An
Bord
Pleanála

Record of Meeting ABP-321557-24

Case Reference / Description	Proposed Development of a Solar Farm, 110kV Substation, an Associated 110kV Grid Connection and all associated ancillary site works. Located in Drumroe East, Cappoquinn and adjacent townlands, Cappoquinn, Co. Waterford.		
Case Type	Pre-application consultation		
1st / 2nd / 3rd / 4th Meeting	1 st Meeting		
Date	6 th February 2024	Start Time	11:00am
Location	MS Teams	End Time	11:50am

DRAWING TITLE	Proposed Grid Connection Route A - Dungarven Substation 1 of 2				
SHEET	A3	SCALE	1:10,000	PROJECT NO.	7286
				DRAWING NO.	1030
				STATUS/ISSUE	A

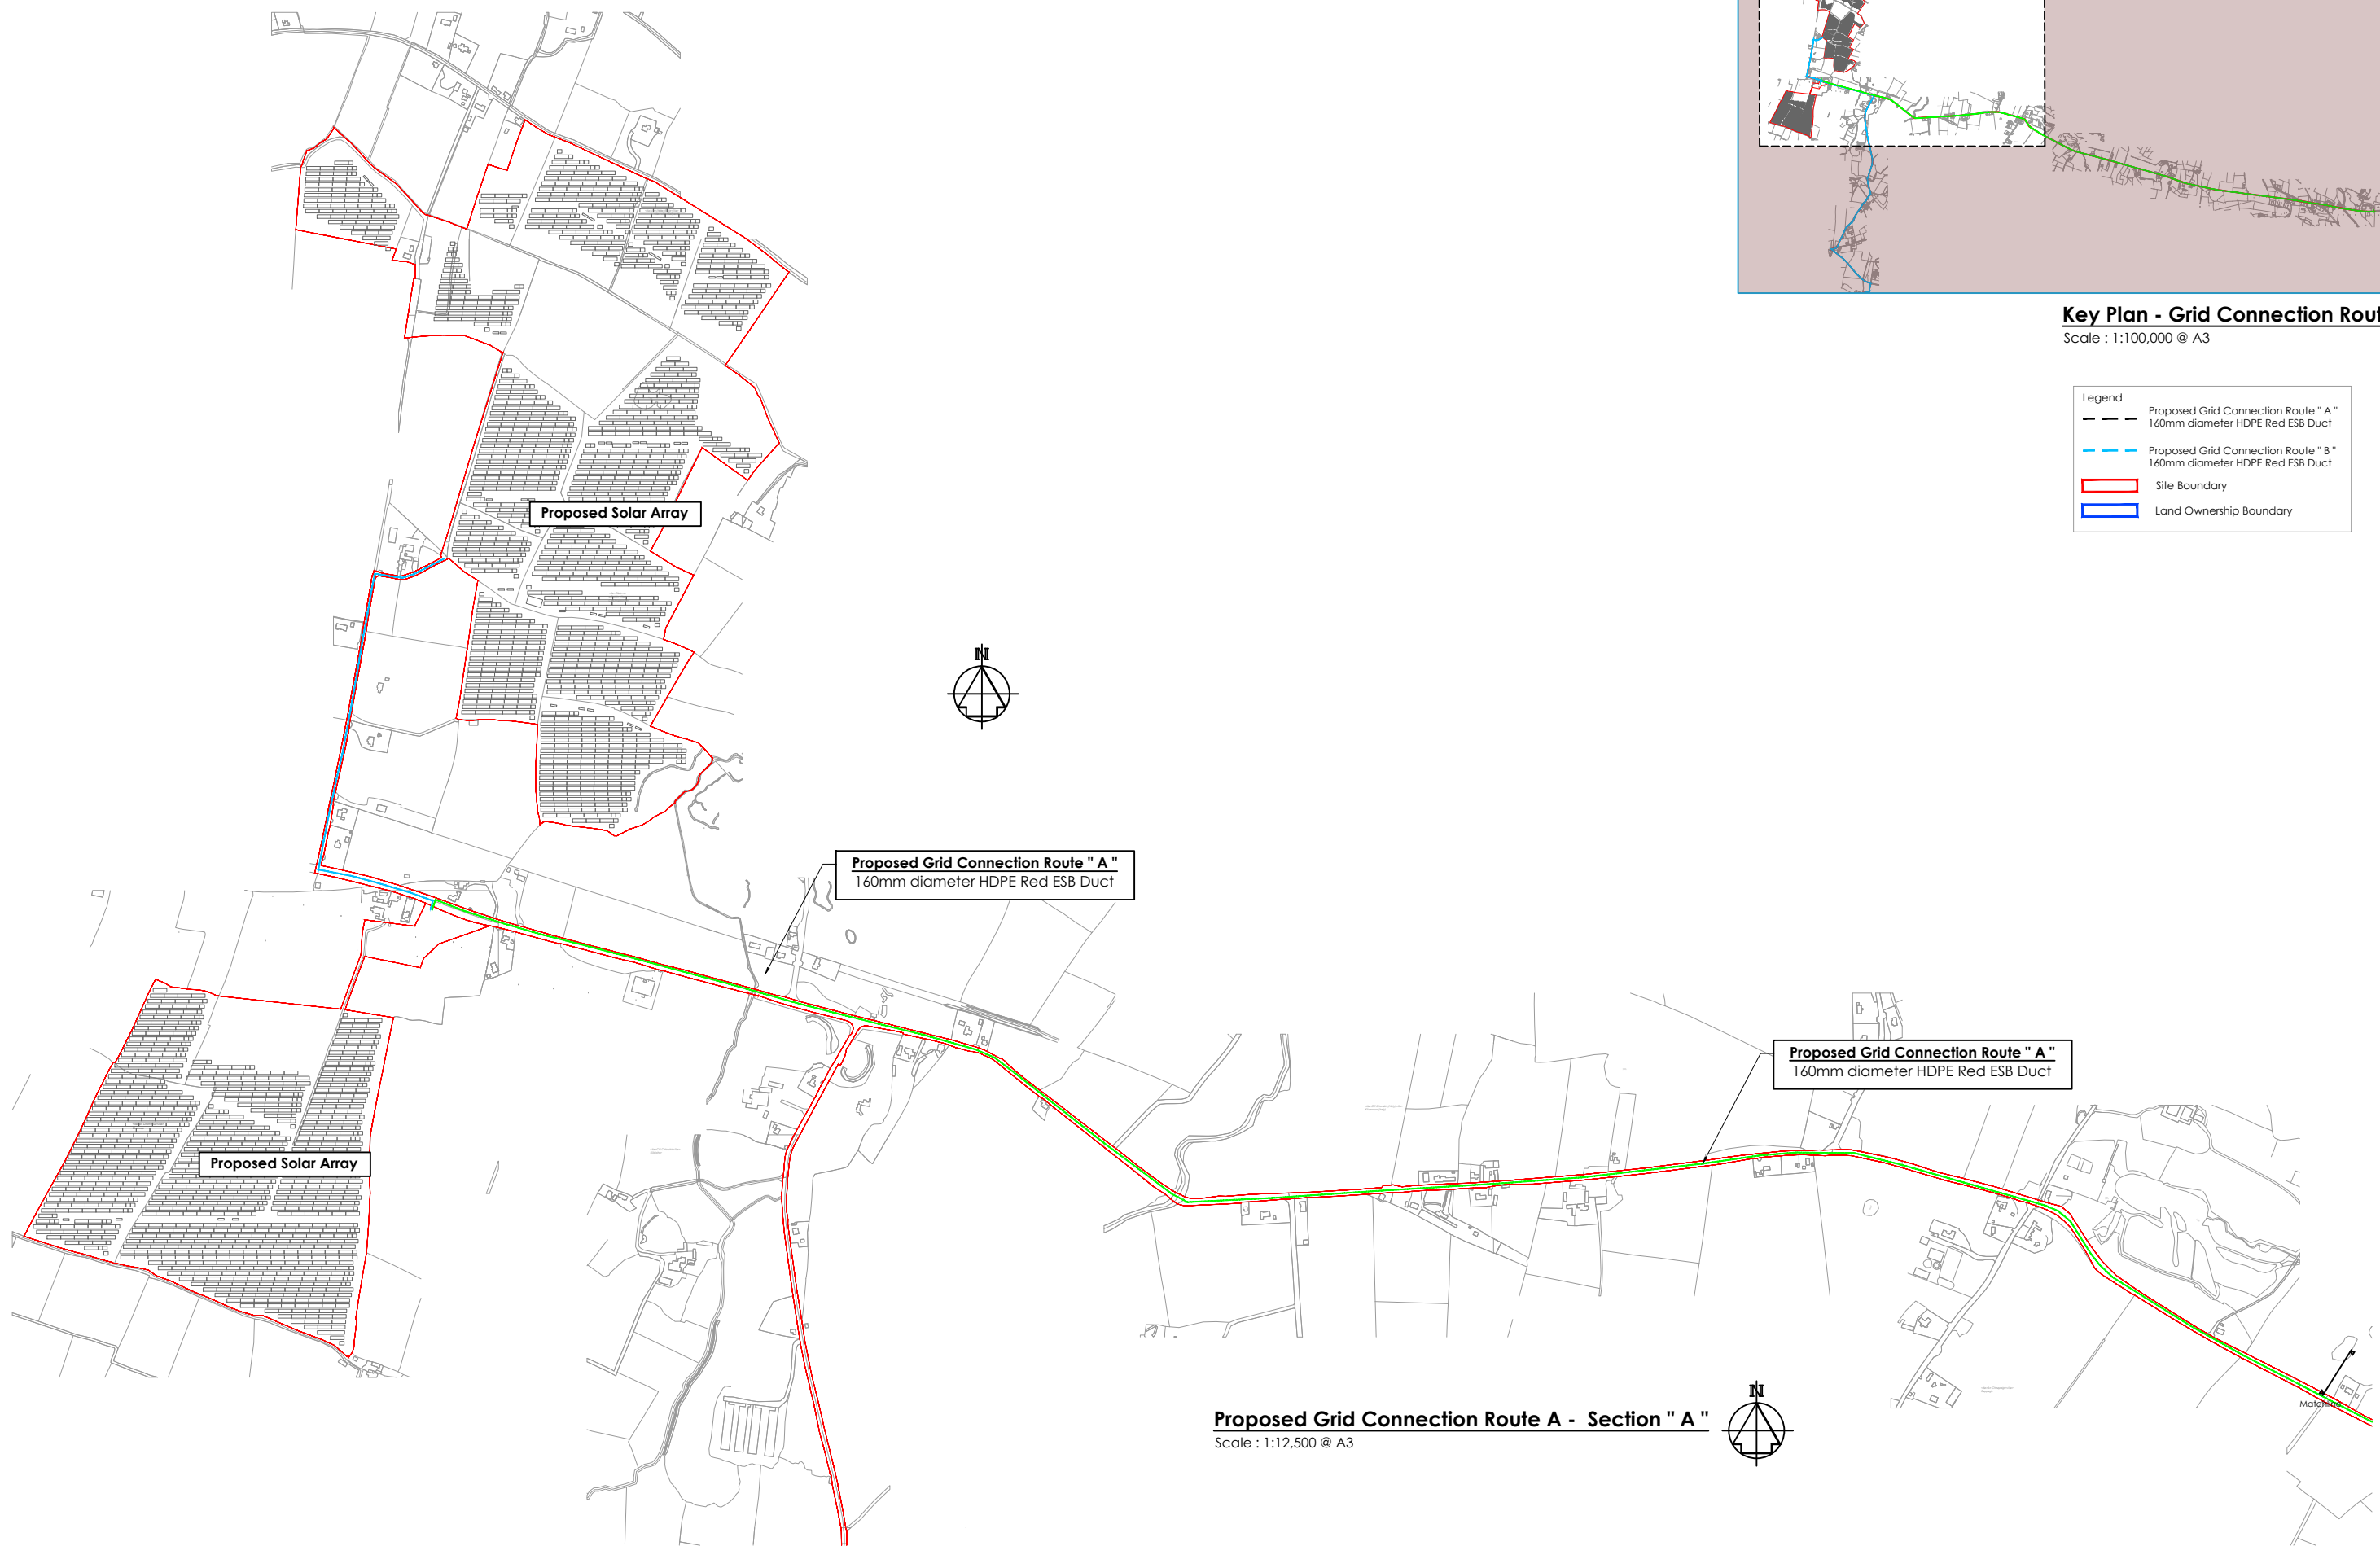
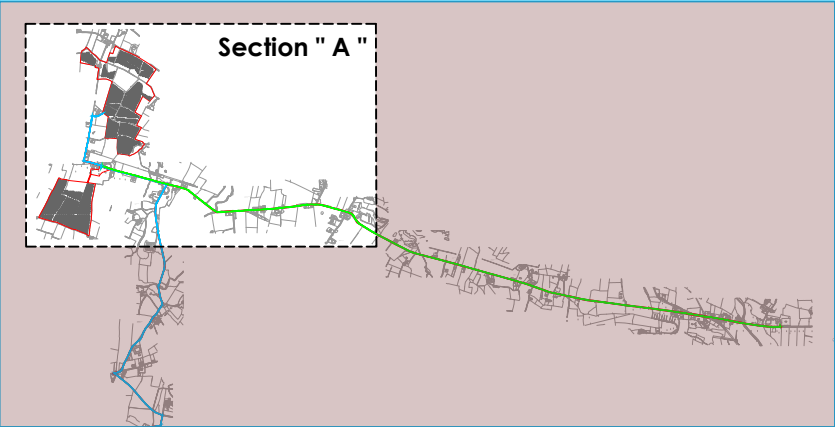
The Boards representatives noted from the planning history that concerns were previously raised by statutory and local authority roads responses regarding the N72 national primary road and the proposed grid connection route in relation to the narrow single-carriageway condition of the road, with heavy traffic and intermittent hard shoulders, and in relation to safeguarding investment. The Boards representatives advised that adequate technical clarity in relation to the proposed construction of the grid connection in the verge should be provided addressing these issues.
